**Consultation Response from Alan Smith,
KC Waste Strategy (Refuse & Recycling)**

2025/91650 143, Upper Commercial Street, Batley, WF17 5DH

Change of use of former public house (sui generis) to HMO (C4) (within a Conservation Area)

Responding Ref: WPN 25 012

Site Layout Plan Proposed

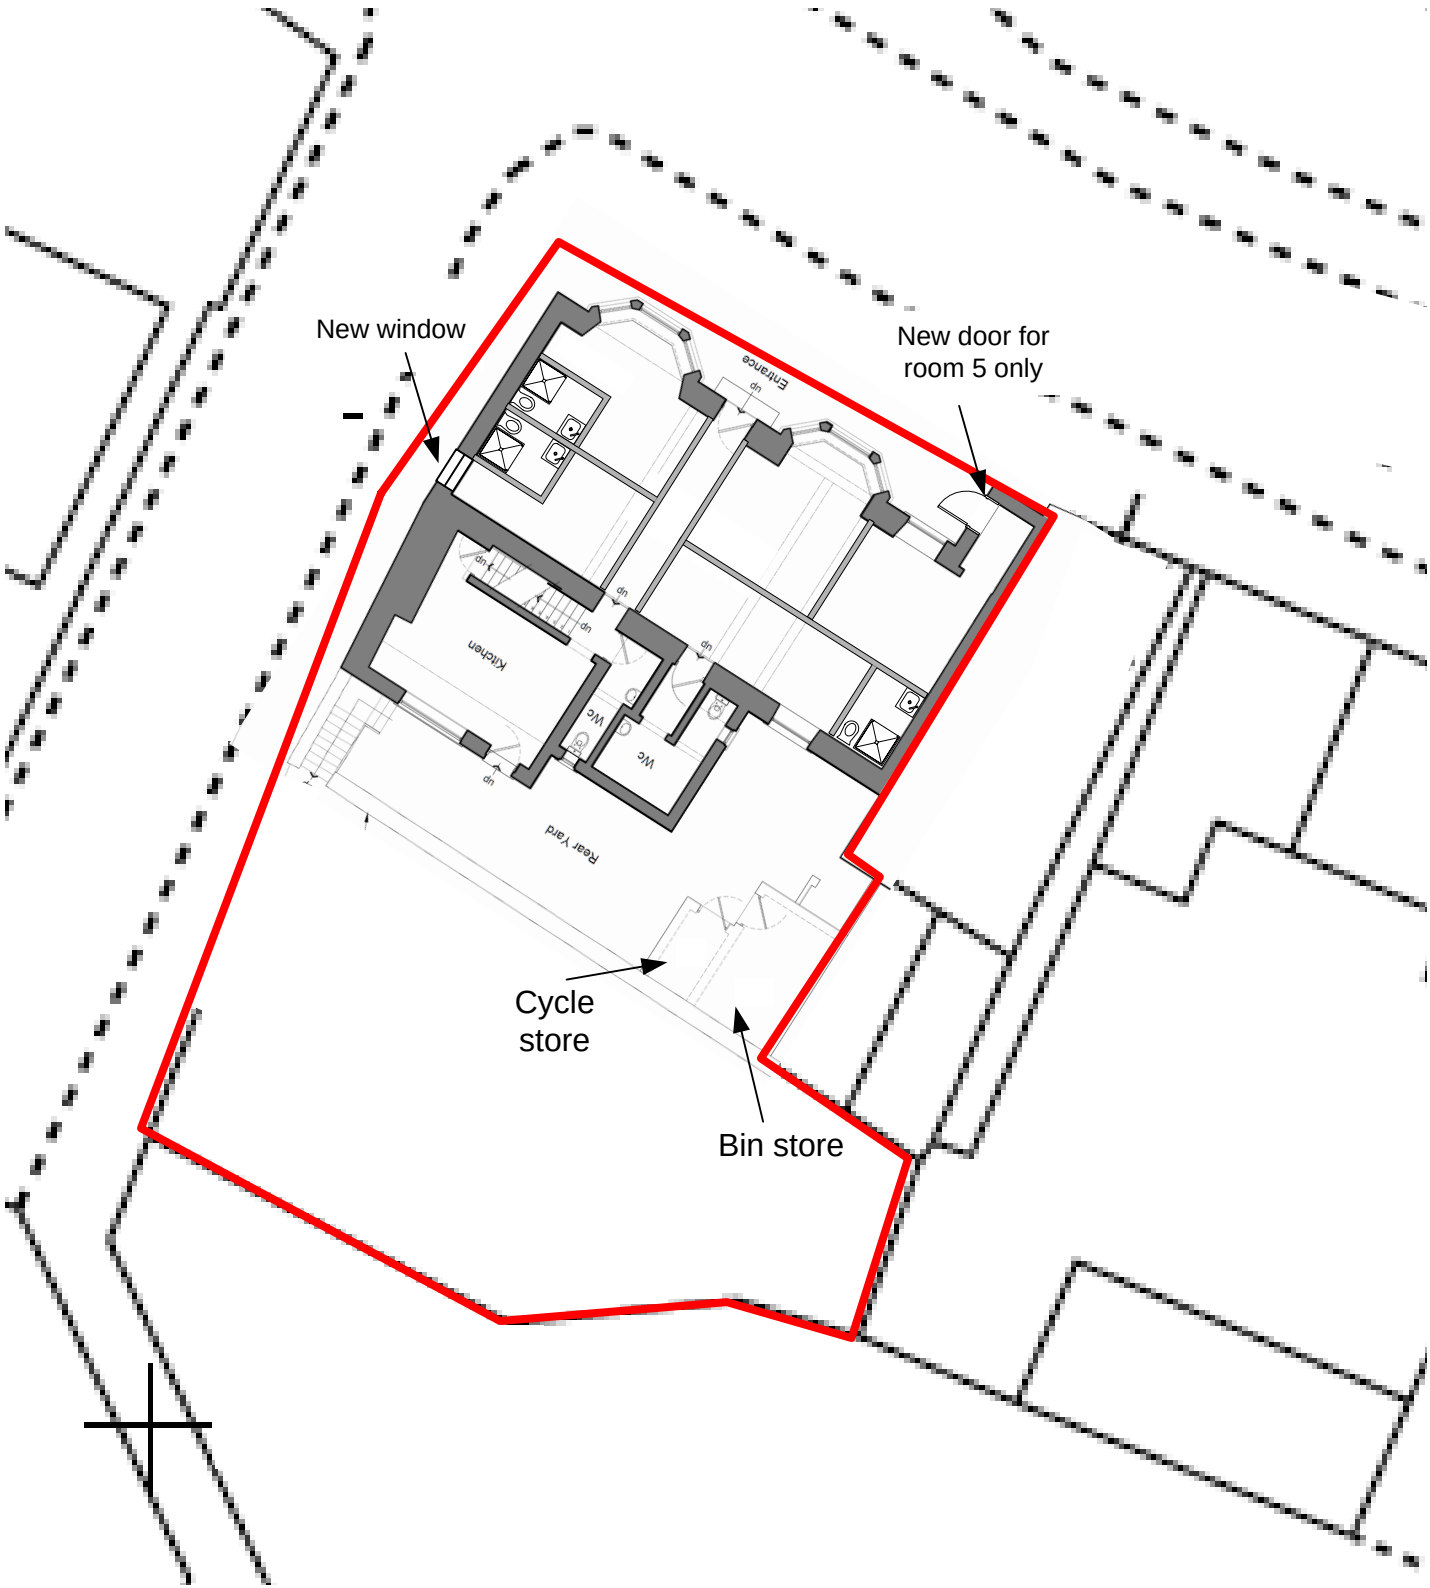
The proposed waste management solution is detailed in the plan "Proposed Site / Block Layout [id 1092805] Size: 938KB 17/06/2025 - UCS006 Site Layout Plan Proposed A3"

- The application is for the construction of 11 HMO apartments. The plan shows the proposed bin store located at the southeast of the site. As the property is a HMO the bin storage area must be able to store 2 x 240ltr residual waste and 1 x 240ltr recycling bin.

- On collection day the bins will need to be placed next to the footway on Mayman Close. If the refuse collection vehicle cannot access the property due to parked cars on Mayman Close the alternative collection option will be for the bins to be brought down to Upper Commercial Street.

- The communal waste storage area should be secured to prevent unauthorised use, rough sleeping, damage or theft. The bin store should be of suitable dimensions to accommodate the bins and constructed in compliance with the details specified in the design guide.

- The bin store must comply with fire regulations (refer to BS 5906:2005 Waste Management in Buildings; BS476-22:1987: Fire tests on building materials and structures; and BS EN 1634-1:2008: Fire resistance and smoke control tests for door, shutter and open-able window assemblies and elements of building hardware) for internal compounds.
- Access from the bin store area to the Bin Collection Point (BCP) on Mayman Close next to the highway should be constructed to withstand point loading and movement, impacts of larger bins over time, and to resist future rutting, pitting, cracking or other such surface degradation that would impair bin manoeuvring. Wheeled bins must not be permanently stored on the pavement or highway on Mayman Close. There should be room to accommodate 2 x 240ltr bins at the BCP.

- A. Before development commences, details of the management and maintenance of refuse storage areas and presentation of bins to the BCP on collection day, by a designated private management company shall be submitted to and approved by the Local Planning Authority. The approved details shall be provided before first occupation and shall be so retained thereafter.
